R/98/26/I

Address: The Lodge Worthing Road Rustington BN16 3PS

Proposal: Listed building consent for replacement of 6x existing windows within the main dwelling with timber framed, double glazed, leaded light effect windows and replacement of 2x windows and 1x door in 1980's rear extension with slimline, leaded light effect, heritage aluminium windows and door

EXISTING ELEVATIONS

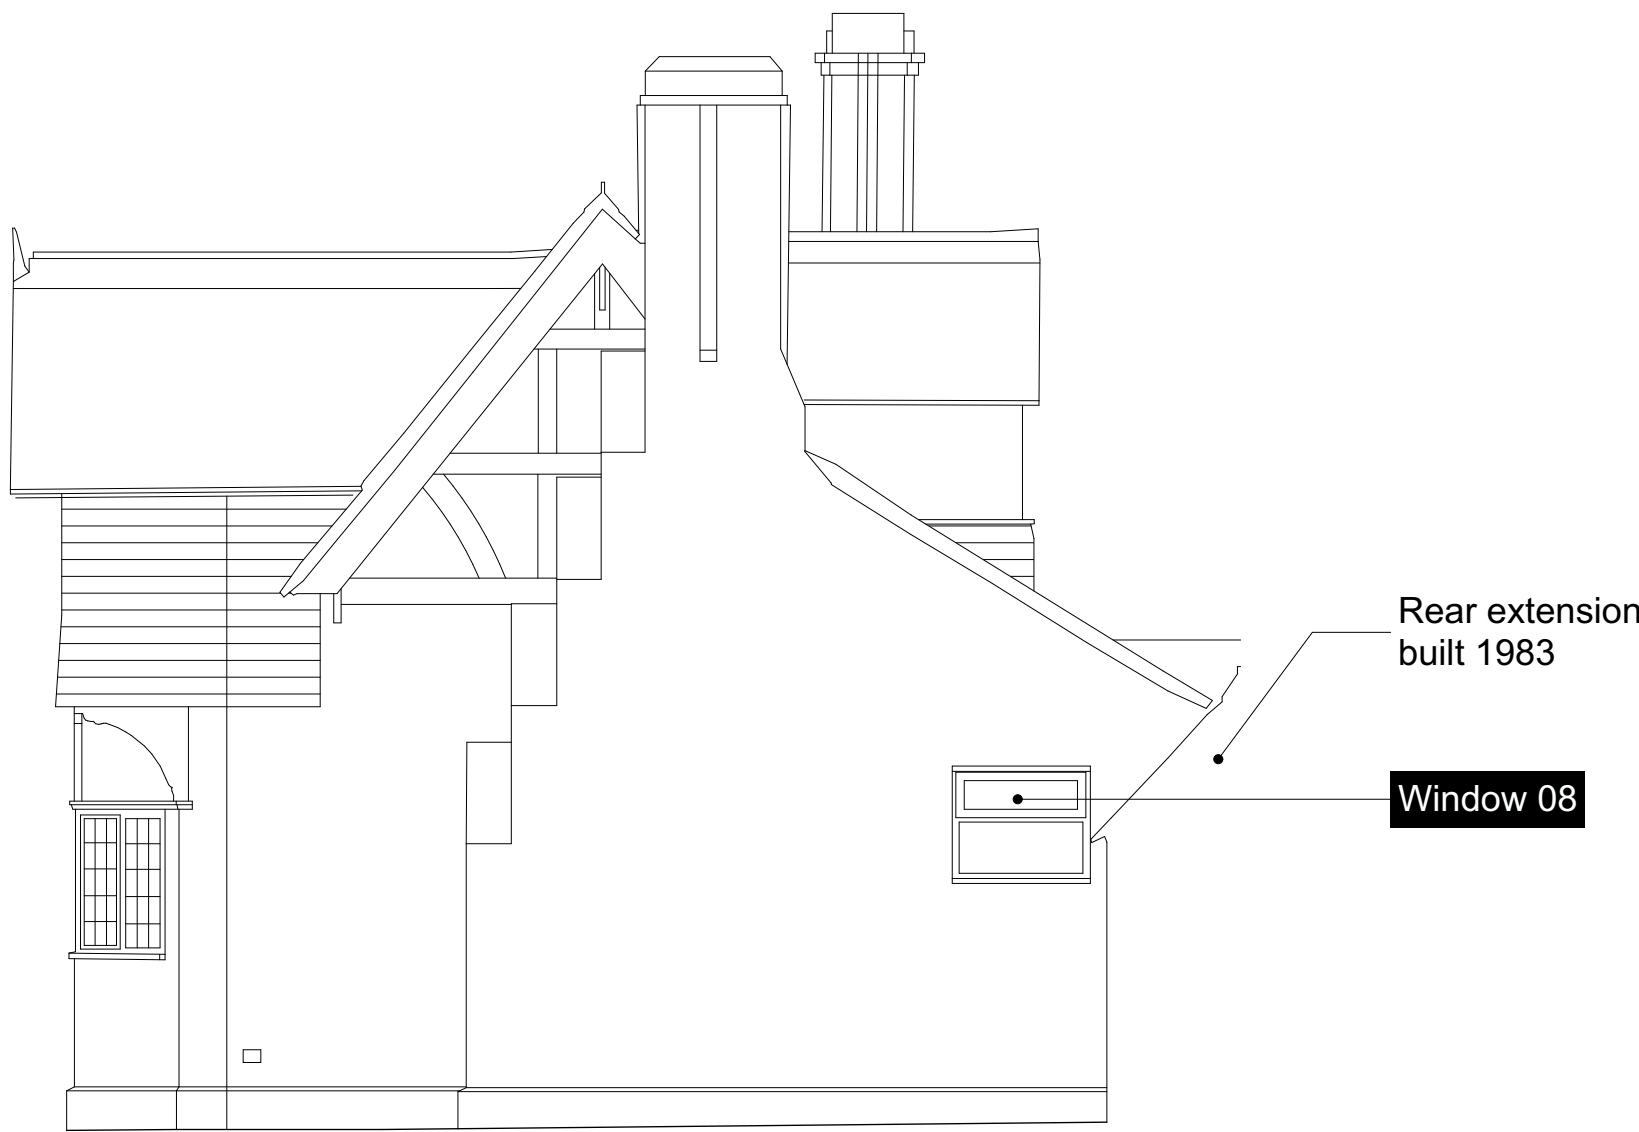
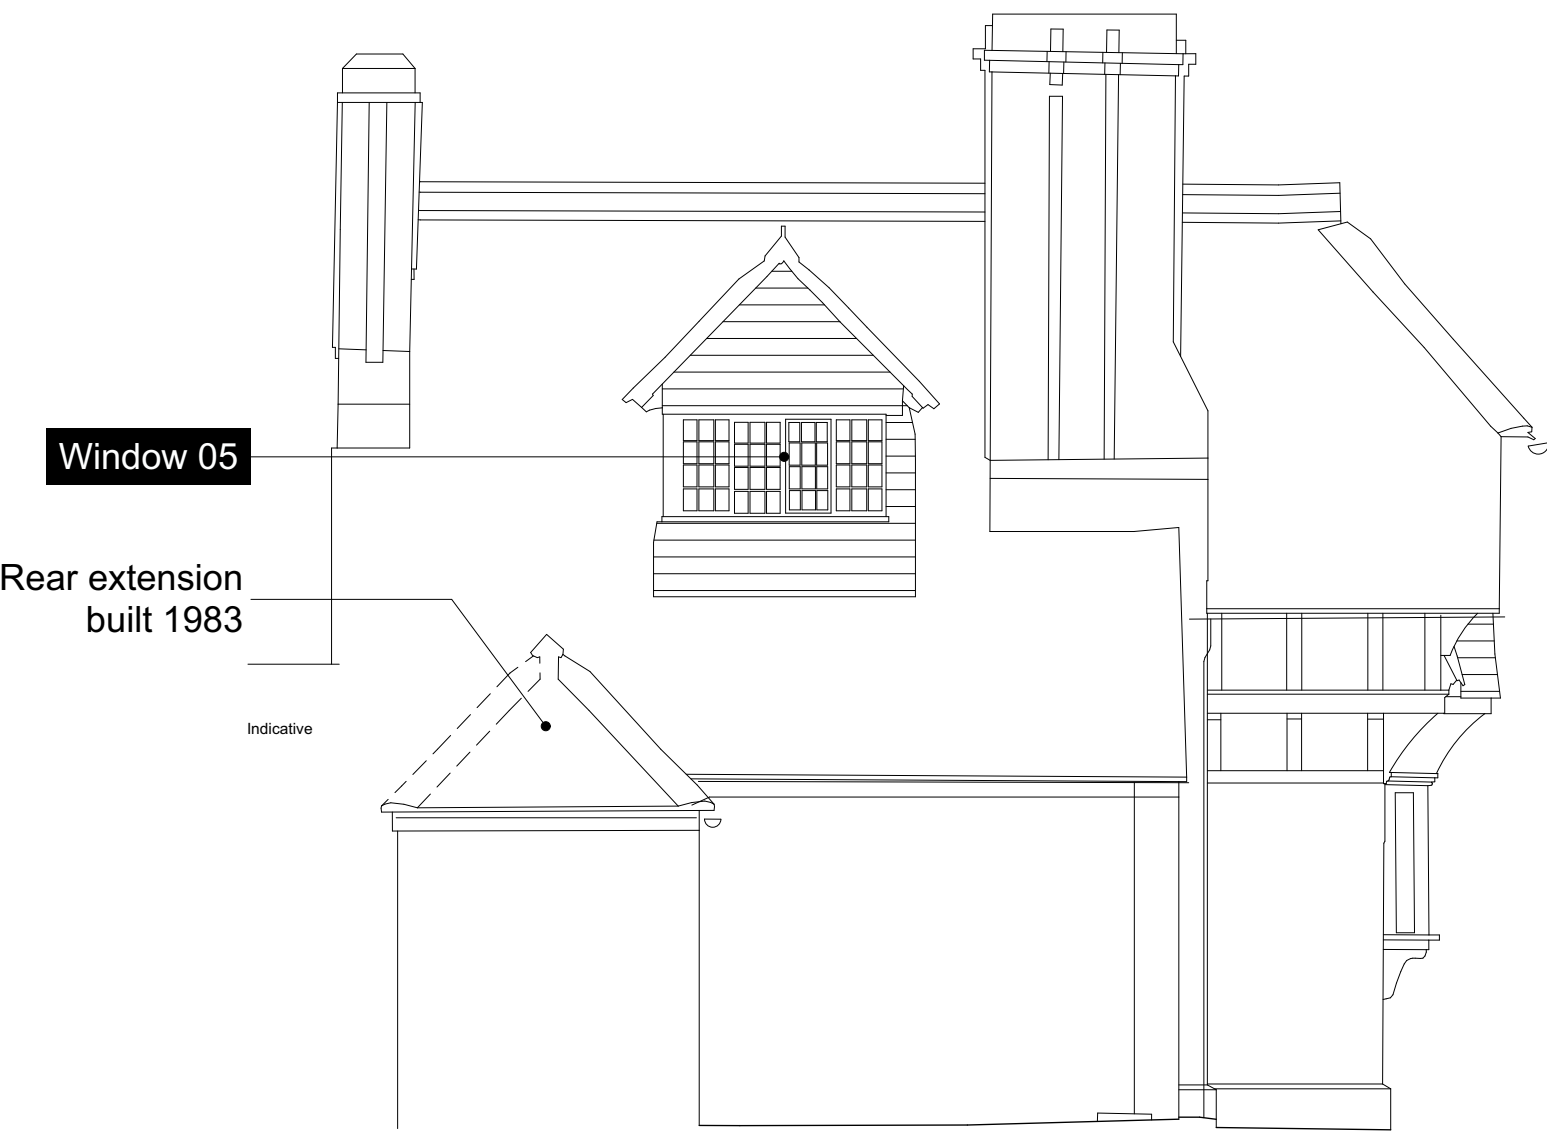
The existing windows within the original part of the building are traditional leaded-light windows with slender metal casements set within timber frames. As such, they make a positive contribution to the character and significance of the listed building.

Historic England advises that traditional windows are often an important part of a listed building's significance and that their alteration or replacement can have a profound effect on its character and appearance. From a previous site visit, and references within the submitted drawings, it is clear that the windows are in a poor state of repair. However, no condition survey or other supporting information has been submitted to demonstrate that the windows are beyond repair or that replacement is the only viable option.

PROPOSED ELEVATIONS

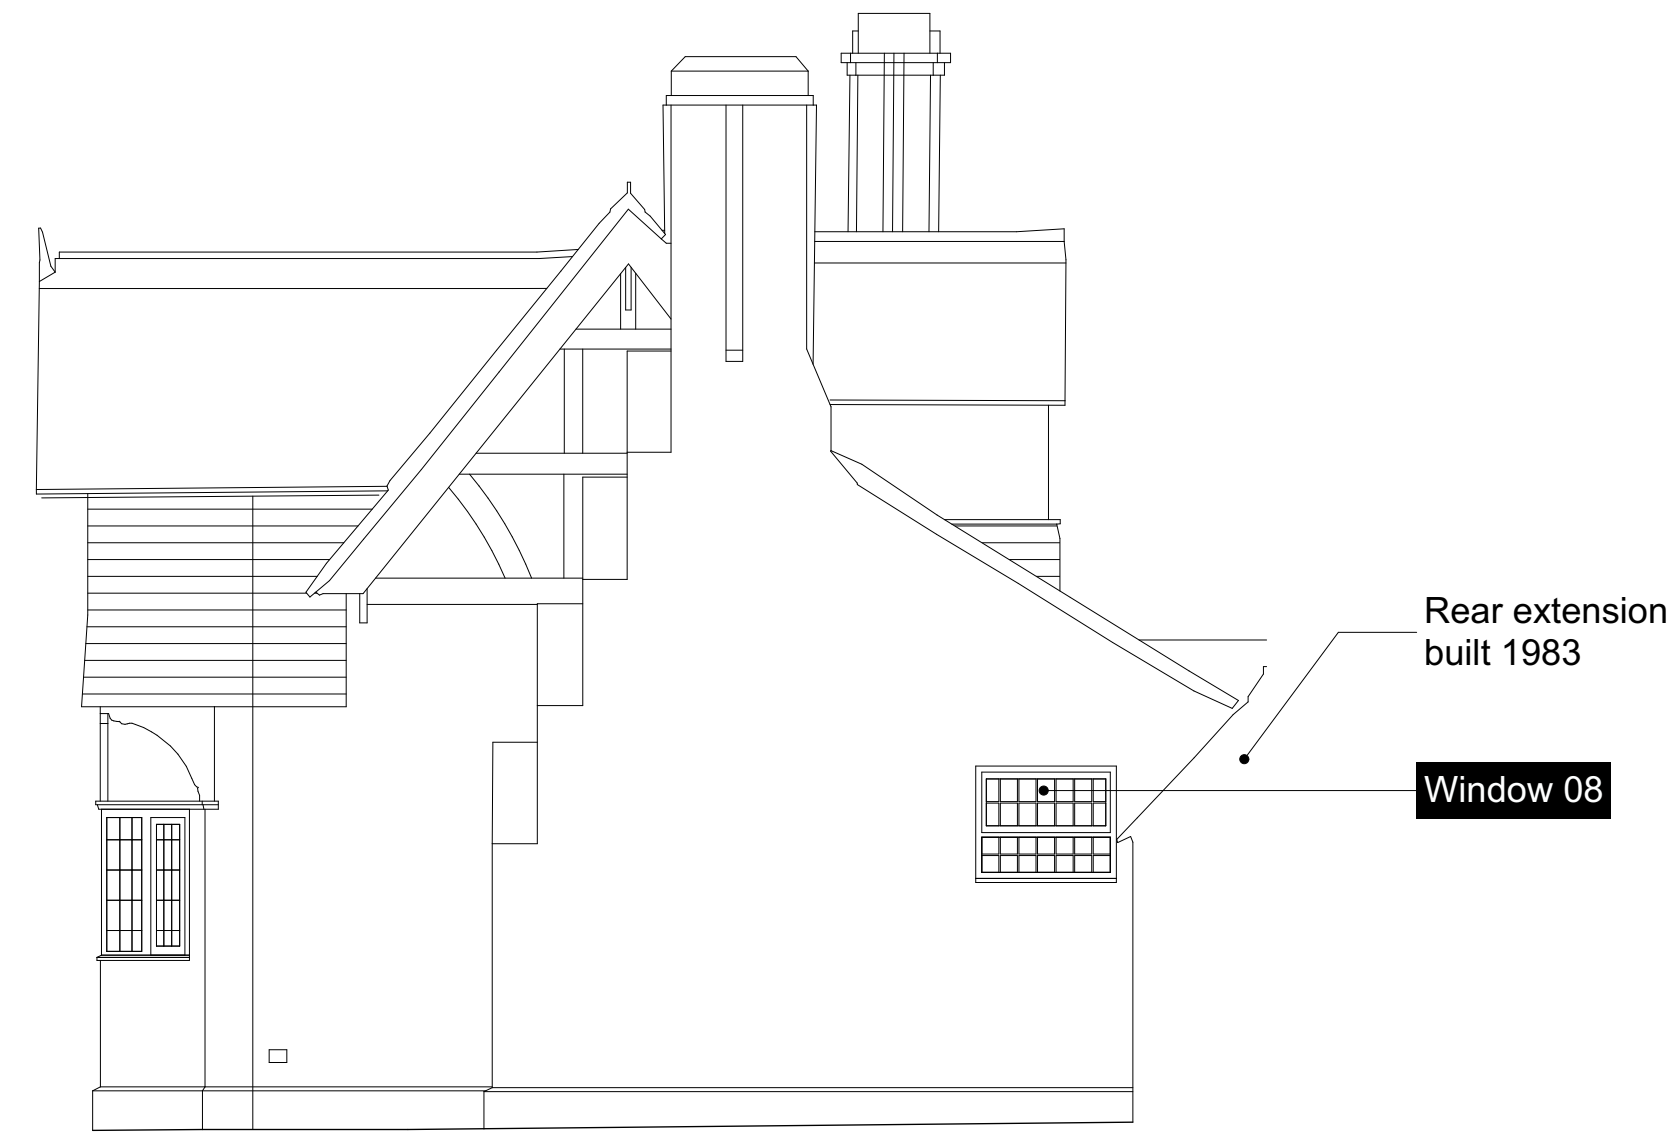
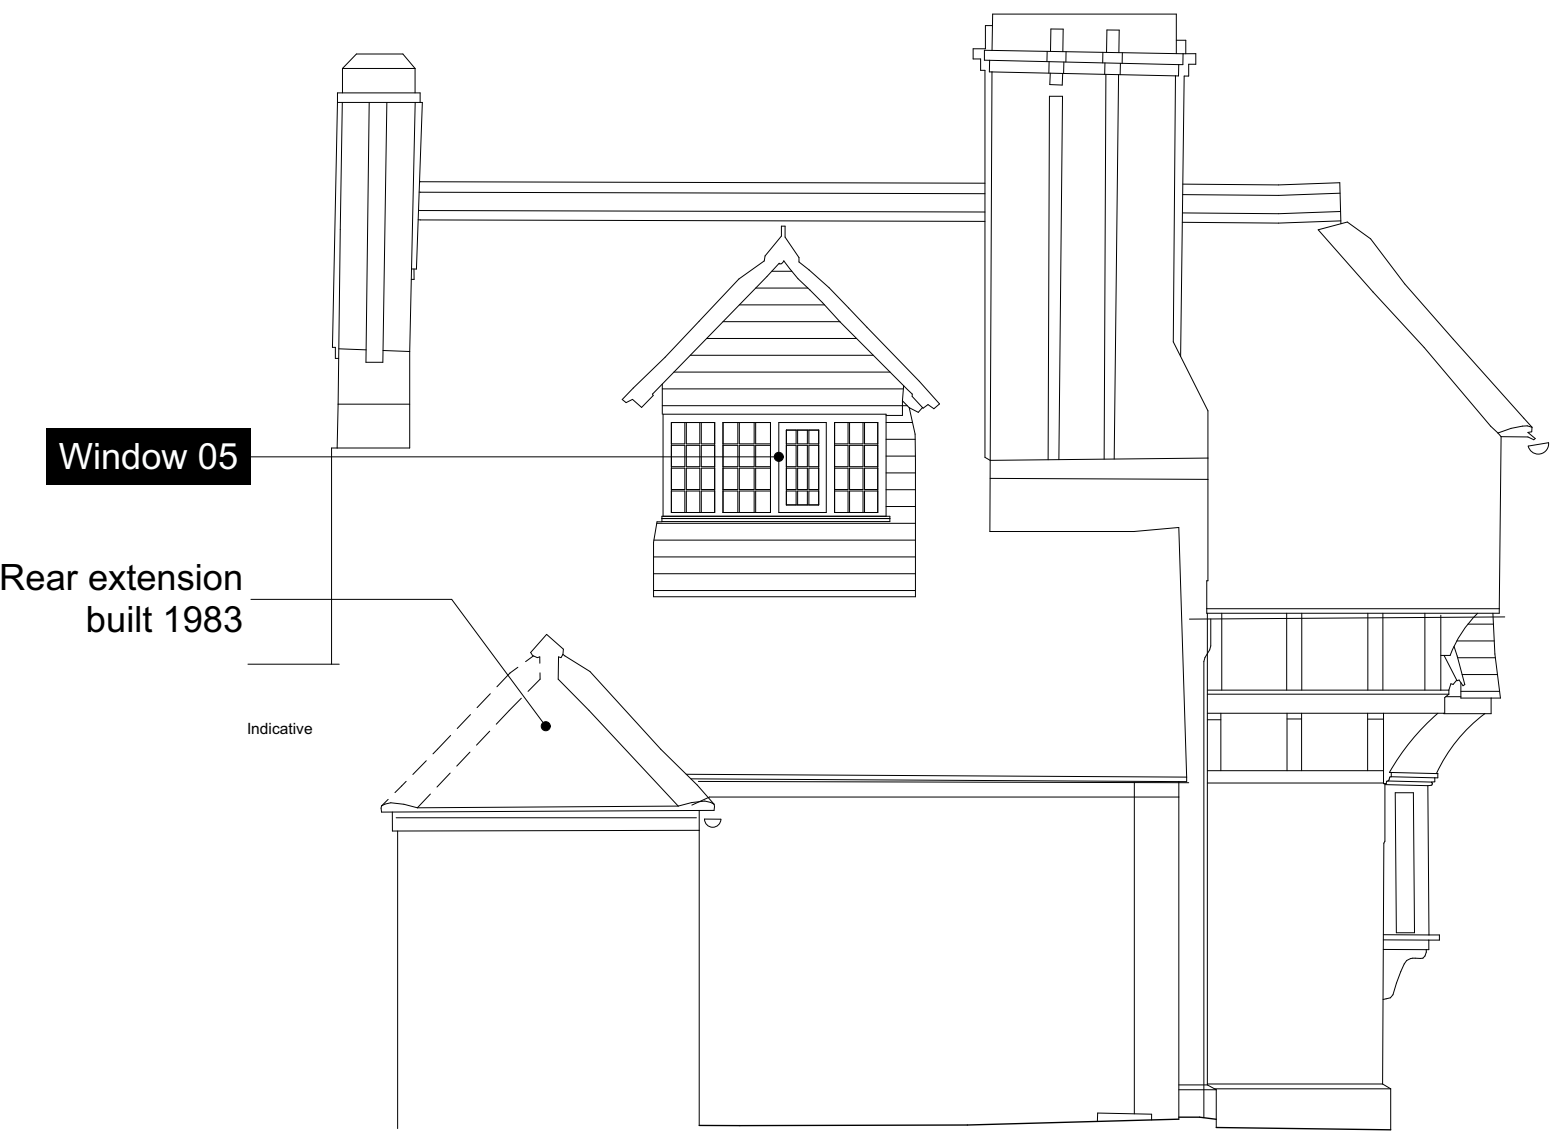
Furthermore, whilst replacement may be acceptable where repair is not possible, the proposed windows would fail to preserve the appearance and character of the existing windows. The incorporation of slim double-glazed units and applied leadwork necessitates altered frame profiles, resulting in a noticeably heavier and less refined appearance than the traditional single-glazed leaded lights. Applied leadwork does not replicate the depth, texture or craftsmanship of true leaded lights and would erode the historic character of the windows. As such, the proposal would result in harm to the significance of the listed building. Consideration should therefore be given to repair, or replacement on a like-for-like basis, potentially combined with sensitively installed secondary glazing.

The proposed aluminium windows within the later extension are acceptable in principle as they would not affect historic fabric. However, it is unclear why the proposed designs have been chosen. For example, Window 07 could be redesigned to better reflect the character of the building, whilst the proposed door would benefit from a simpler design with less, or no, applied lead detailing.
